Application by Millbrook Power Limited for an Order Granting Development Consent for a Proposed Millbrook Power project

The Examining Authority's Written Questions and Requests for Information (ExA WQs)

Issued on Tuesday 20 March 2018

- Legend:**
- Order Limits
 - Generating Equipment Site
 - Electrical Connection Site
 - Gas Connection Site
 - Power Generation Plant Site
 - Overlap between Electrical Connection Site and Generating Equipment Site

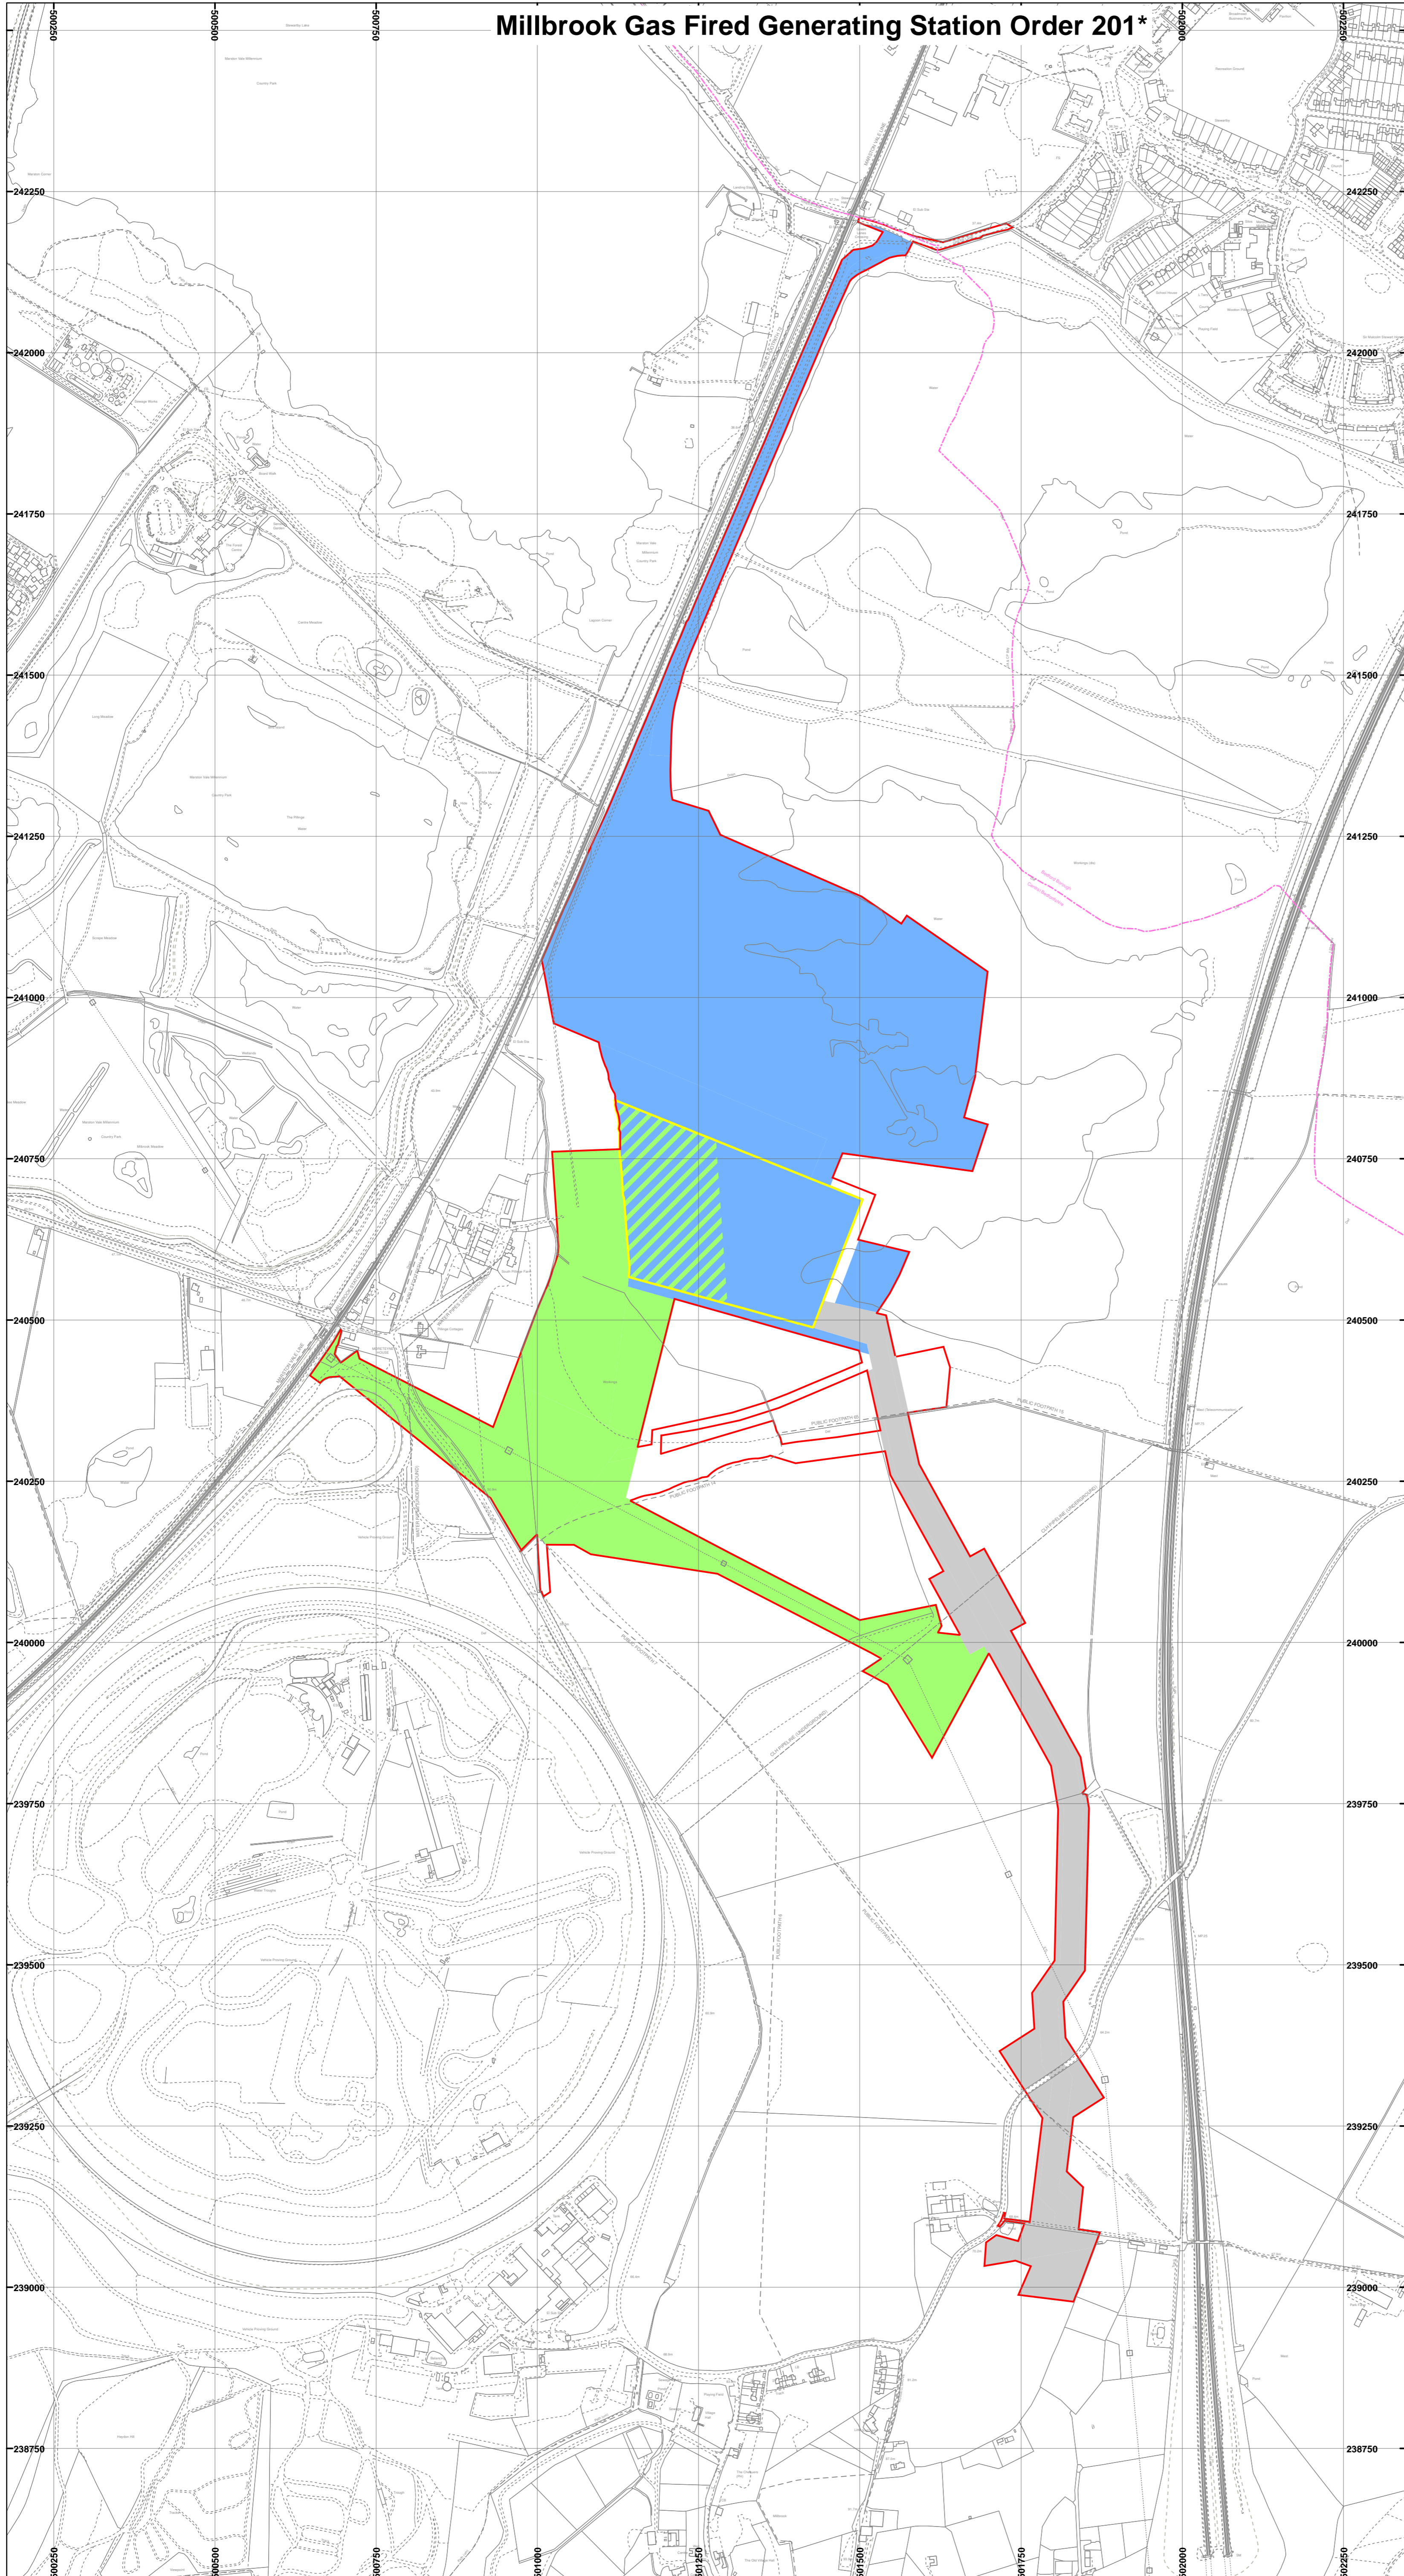
1.0.3	Applicant	Figure 1.2 of the ES shows separate coloured areas for the Generating Equipment Site, the Electrical Connection and the Gas Connection. Other areas within the Order Limits are shown in white. Please set out the reason for the inclusion of these white areas and the use that will be made of this land.

1.0.4	Applicant	ES Figure 1.2 shows a substantial area in blue marked as the Power Generation Plant Site. The area to the north of the Generating Equipment Site appears to be land that would largely be occupied by the Covanta Resource Recovery Facility (Covanta RRF). Please explain why all of that land is included in the Order Limits. To the extent that some of this land is required in order to provide access to the Generating Equipment Site can an access corridor be specifically identified?

1.0.8	Applicant		ES paragraph 3.1.13 refers to road access to the site being shown on Figure 1.2 and paragraph 3.2.15 refers to a temporary construction laydown area. Figure 1.2 does not show either of these elements. Please confirm whether the access routes listed here are those shown in Figure 12.2 and the laydown areas are as shown in Figure 3.1 or provide further figures showing the details.

1.0.11	Applicant		Please explain the two footnotes to ES Table 3.1.
1.0.12	Applicant		ES paragraph 3.2.17 refers to the "Access Road" and the "Short Access Road". Please identify the location of these roads on ES Figure 1.2 or other plans.

Date	02/2015
Scale	1:15,000 @ A4
Drawn By	HF
Checked By	RE
Revision Number	01
Figure Number	Figure 7.1

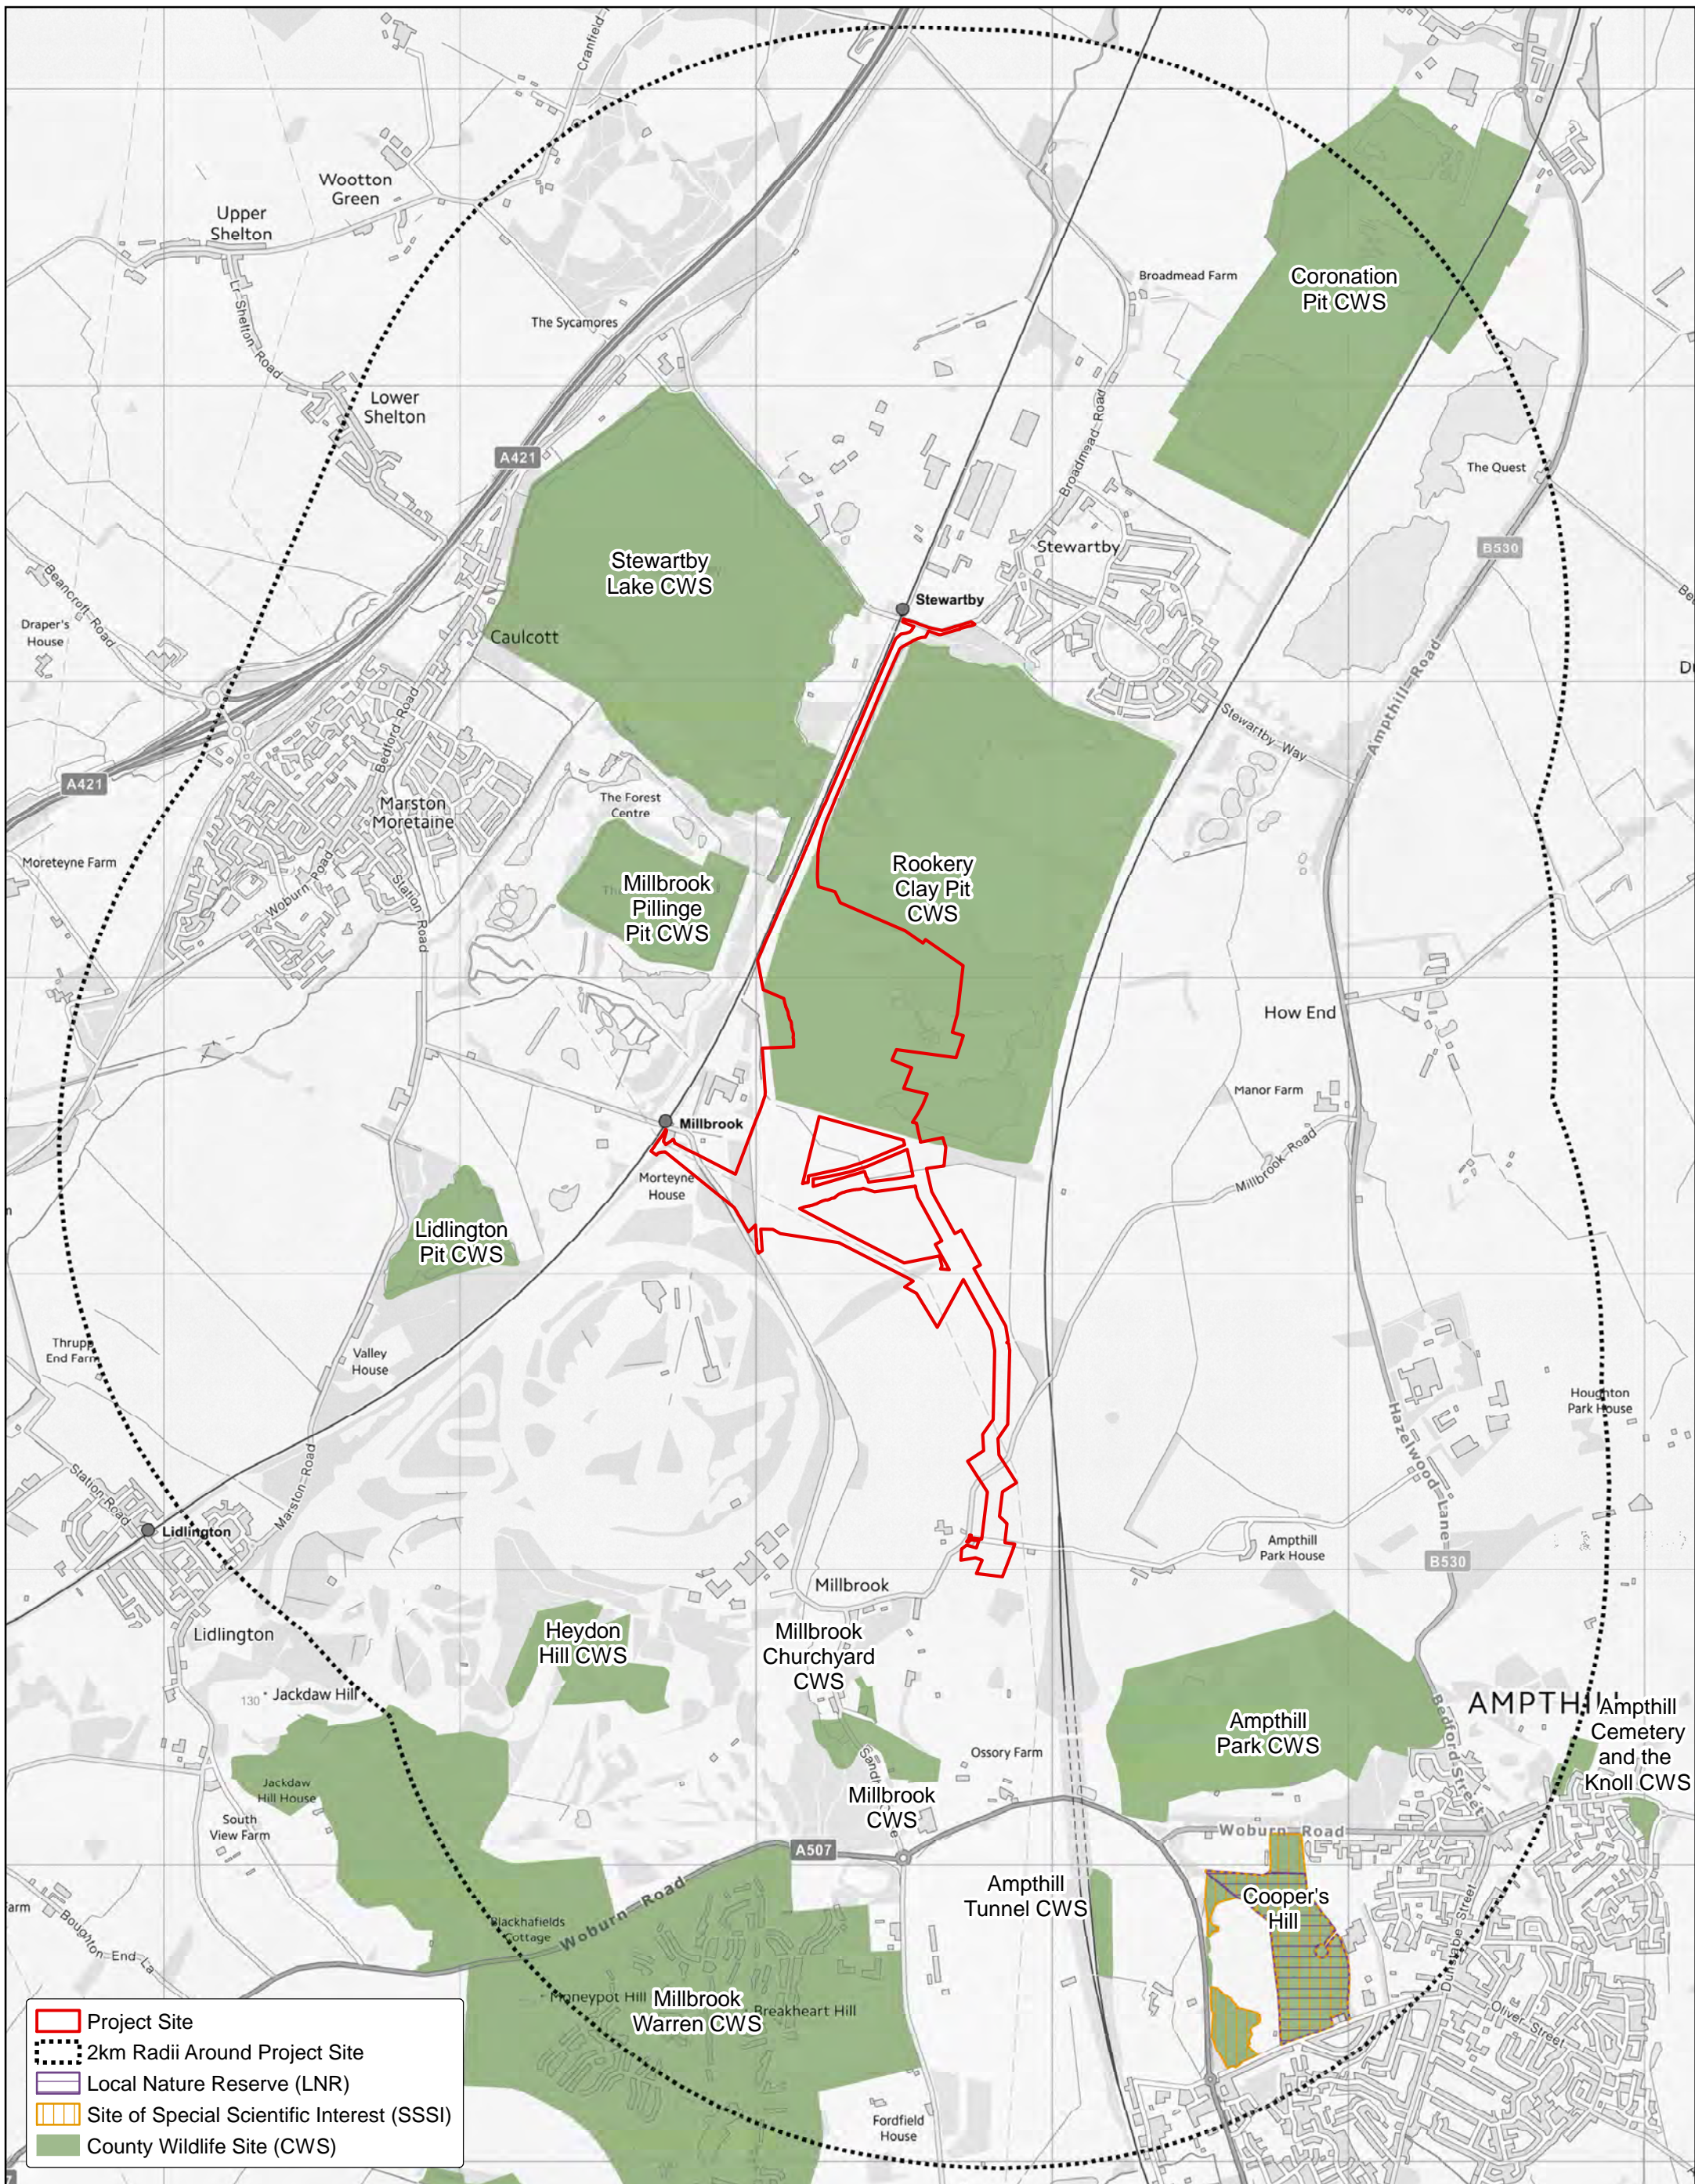
1.4.2.	Applicant		The study area and receptor locations within it are identified in Table 7.3 (page 173 of the ES) and on Figure 7.1 (Doc 6.3, [APP-049]). The study area is defined as extending to 350m beyond the boundary of the Proposed Development site, and was selected on the basis that the nearest noise sensitive receptors (NSRs) to the Proposed Development lie within 350m of the

1.4.3.	Applicant		Moreteyne House is identified in Table 7.3 of the ES as only likely to be impacted by noise during construction and decommissioning of the electrical connection. However, it appears (from Figure 7.1) to be in close proximity to Pilling Cottages and South Pilling Farm, for which noise impacts are also anticipated from the gas turbine generator, exhaust gas flue stack and fin fan cooler(s). Please explain the reasoning for this conclusion.
